**KIRKLEES METROPOLITAN COUNCIL
INVESTMENT & REGENERATION SERVICE**

DELEGATED DECISION TO DETERMINE PLANNING APPLICATIONS

Reference No:	2022/62/91512/W
Site Address:	6-8, High Street, Scapegoat Hill, Huddersfield, HD7 4NJ
Description:	Erection of single storey front extension
Recommending Officer:	Sam Jackman

DECISION – Refuse

Dwg ref: 6-8HS/P03 : Scale 1:100 @ A3 : November 2021

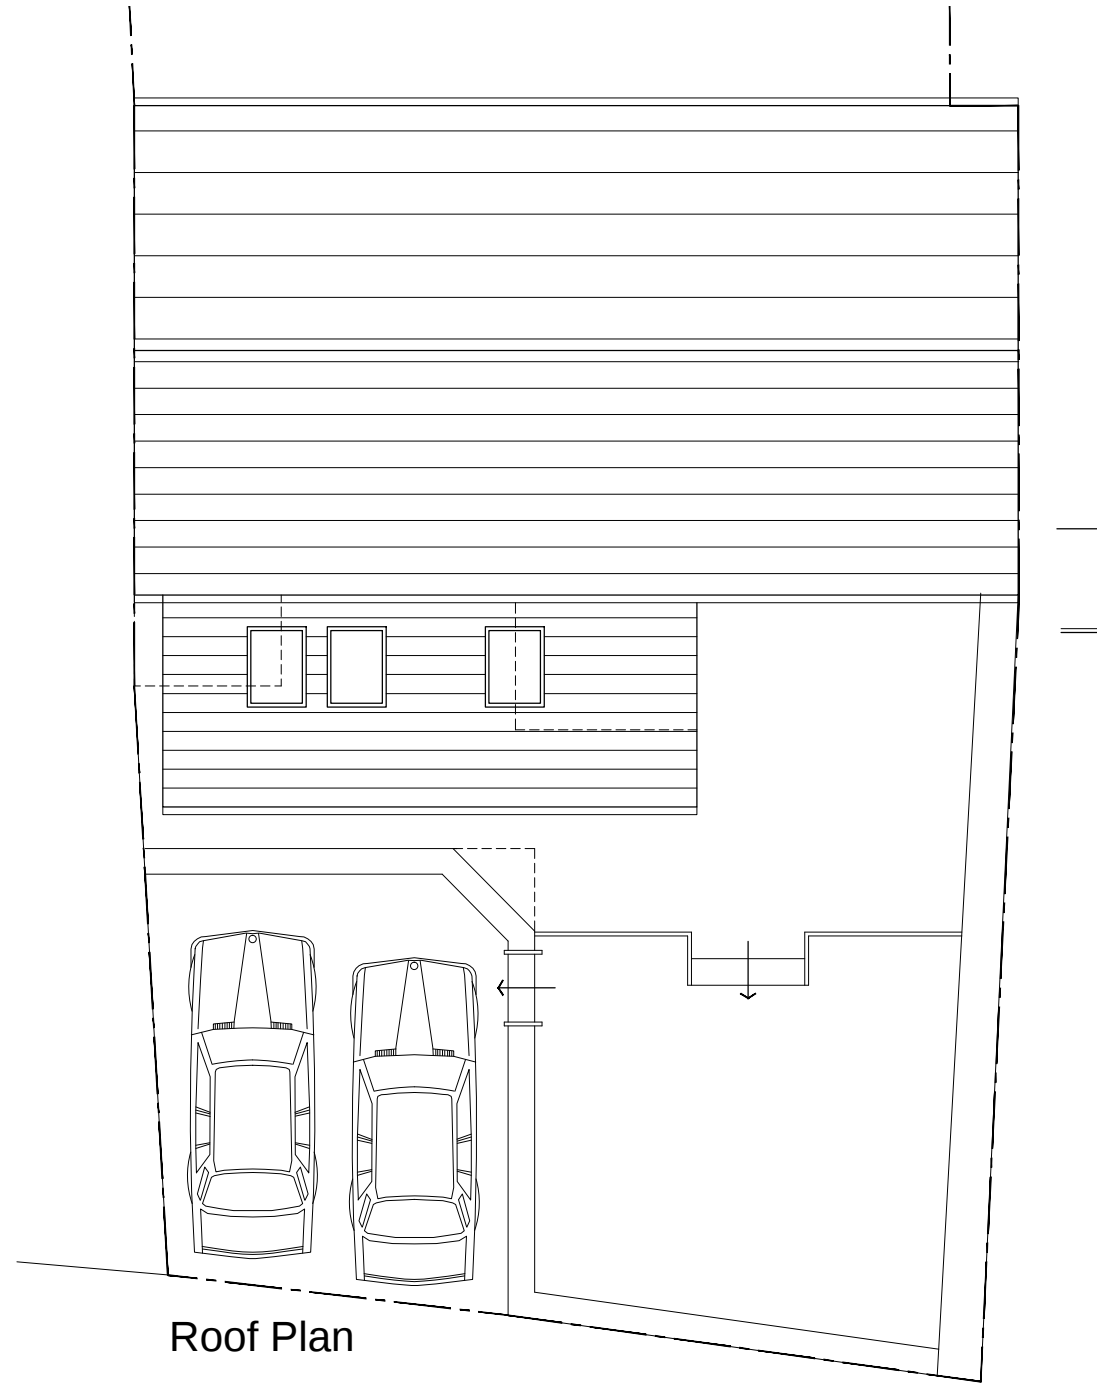
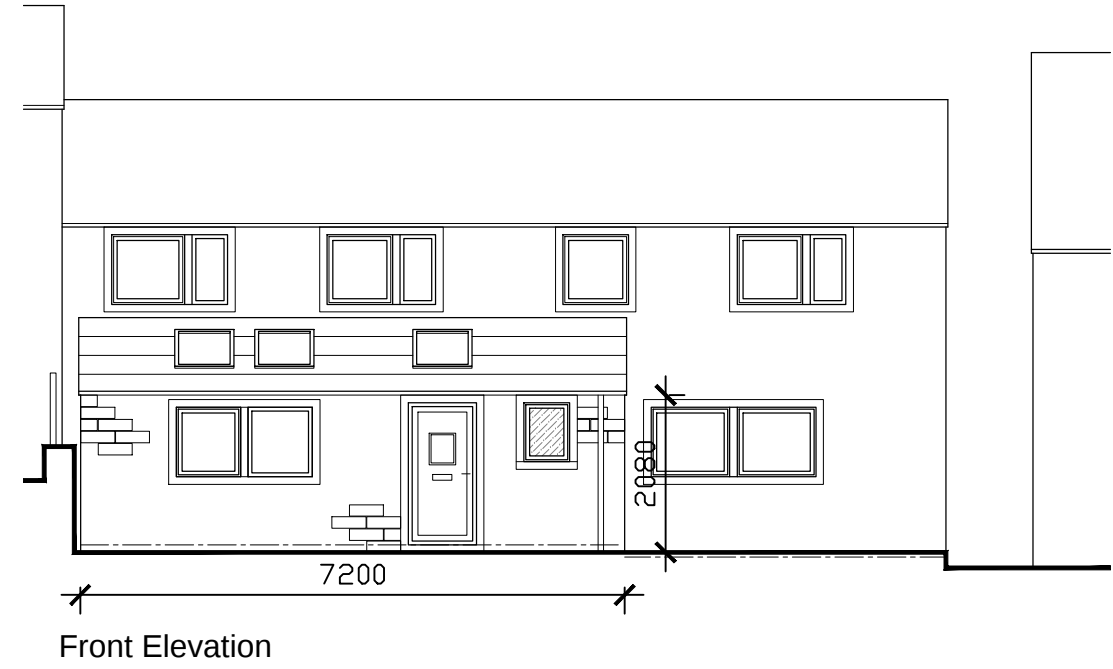
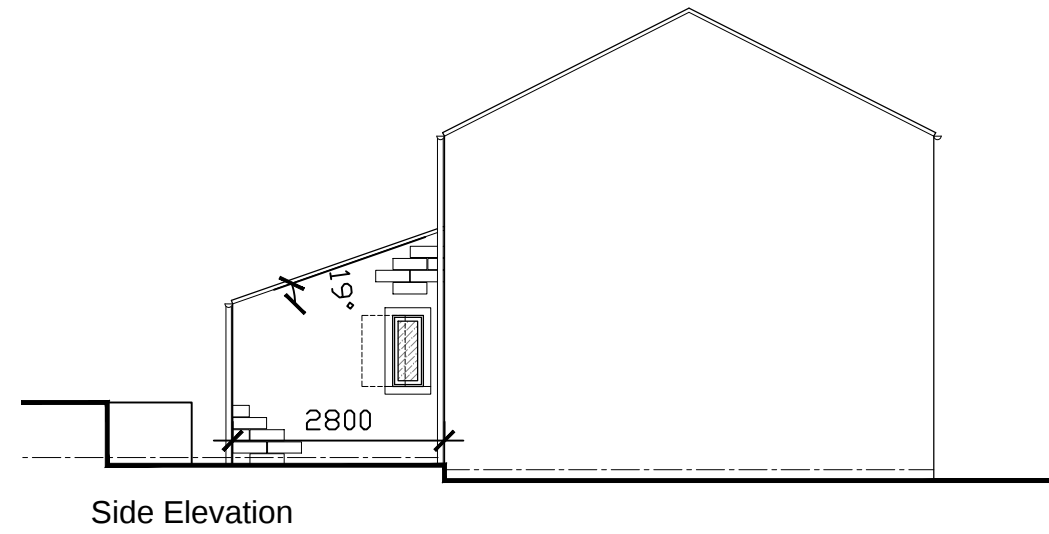
The extension itself has a footprint of 20.16m², and albeit designed with a lean-to roof, it would not be seen as subservient and it is considered to dominate the host property given its length extending over ~62% of the front elevation, combined with the 2.8m projection. Of note, where there are extensions to largely front elevations in the vicinity of the site, these are much smaller than what is proposed and sit somewhat successfully in the street scene. It is therefore concluded the proposal would be visually jarring on the eye with the proposal failing to be suitably subtle, thereby causing detrimental harm to the character of the host property and the wider street scene.

The proposed extension has been designed to include a front door with windows either side where the proposed elevational treatment does not relate well to the vertical arrangement of the existing windows having a staggered relationship with one another and therefore, would harm the appearance of the host property too.

The proposed front extension, given the width of the structure and position of the proposed openings to the front elevation, when viewed in conjunction with the rest of the dwelling and the remainder of the terraced row, would be noticeably dissimilar in character and appearance. Therefore, the proposal would not be in keeping with or respect the street scene and therefore, would not comply with the guidance within the House Extensions and Alterations SPD.

However, it is accepted that a lean-to roof is acceptable in its design, and that the SPD does not stipulate what is small in scale, this has to be taken on an individual case. Where in this case as mentioned above that a 7.2 m wide extension projection 2.8m covering 62% of the frontage is not considered to be subordinate or small.

1. The proposed development, by reason of its siting, scale, projection and fenestration detailing would fail to represent a subservient and harmonious addition to the host property, and would appear as a dominant feature to the front of the property and prominent visual intrusion within the street scene resulting in an incongruous form of development. The proposal would thereby cause detrimental harm to the character and appearance of the host property and visual amenities of the locality. The proposal would therefore be contrary to Policies LP1, LP2 & LP24 (a and c) of the Kirklees Local Plan, Principles 1 & 2 and Section 5.13 of the Council's adopted House Extensions and Alterations Supplementary Planning Document and Chapter 12 of the National Planning Policy Framework.

Ground Floor Plan

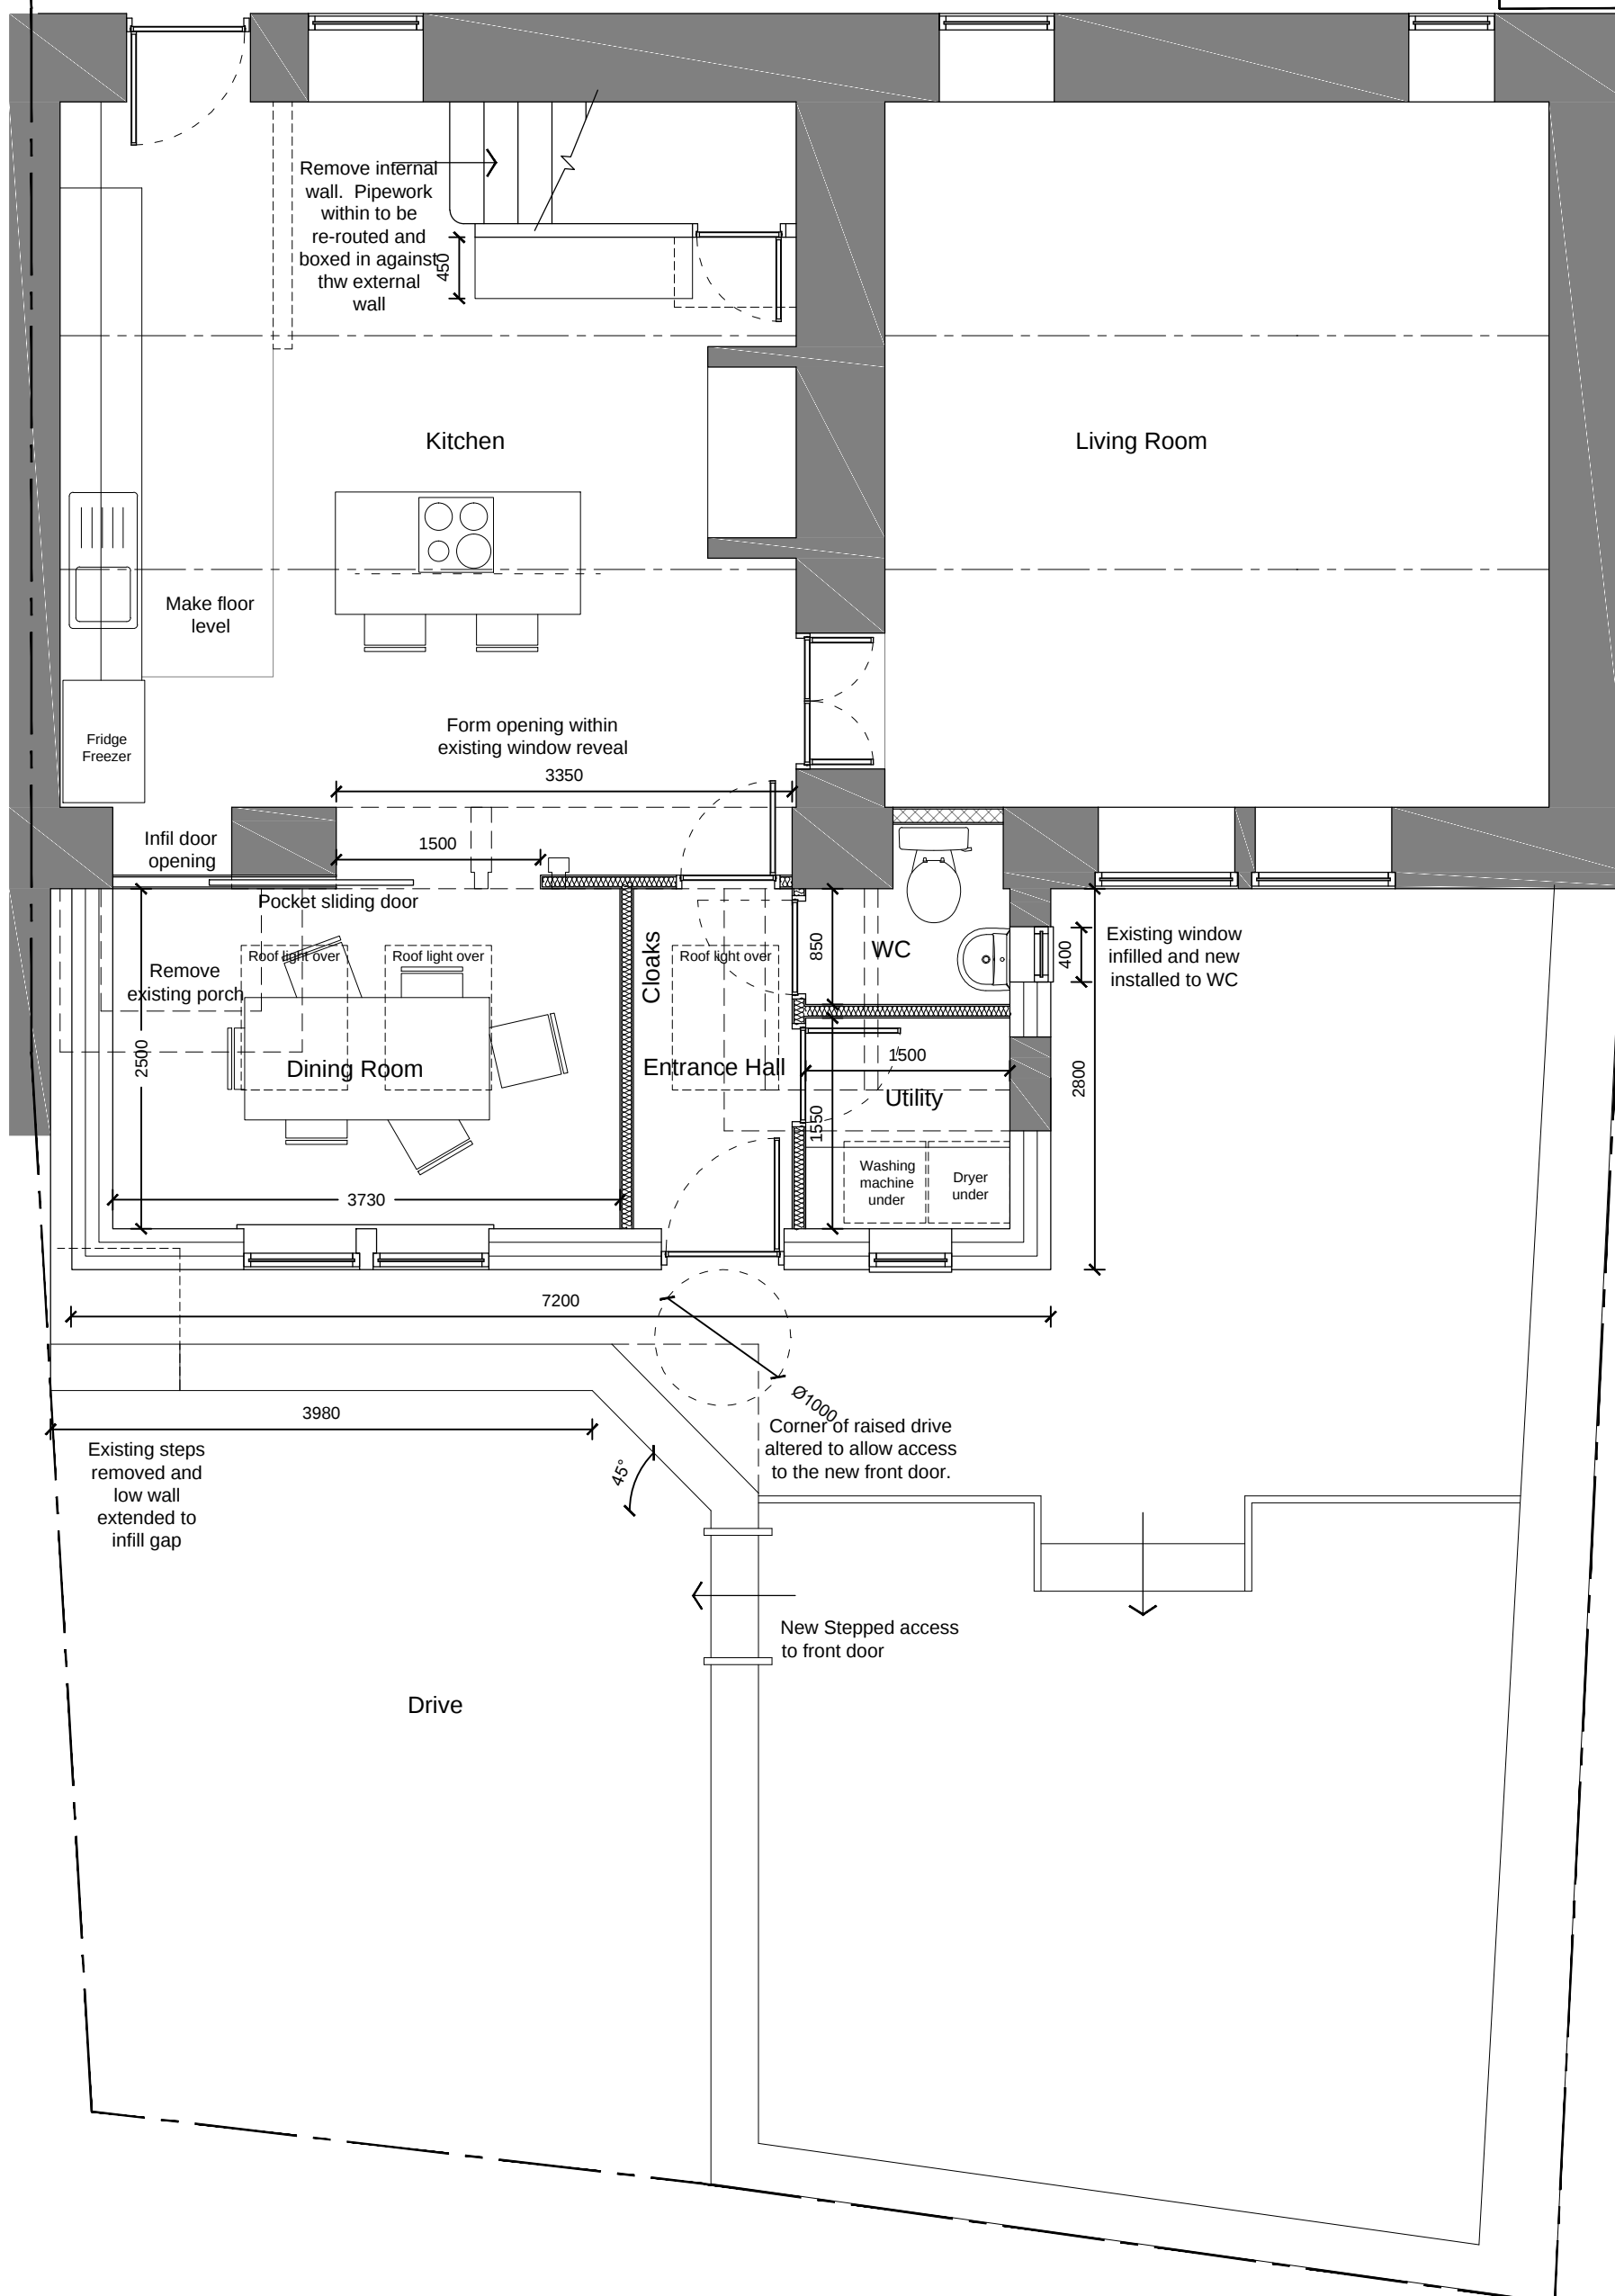
The application is to demolish the 2 existing porches and build a single storey front extension, to create a dining room, new entrance with utility & WC.

- 2.8m in projection
- 7.2m in width
- 2.08m in height to the eaves; 3.1m in overall height with a lean-to roof

In terms of highway safety, the depth of the parking area to the front of the site would be reduced, but Officers consider that the front can still accommodate 1 car. Further to this, the proposal would not result in the creation of a new bedroom. As such, it is considered that the proposal would meet the aims of Policies LP21 and LP22 of the Kirklees Local Plan with respect to highway safety and advice in Chapter 12 of the National Planning Policy Framework.
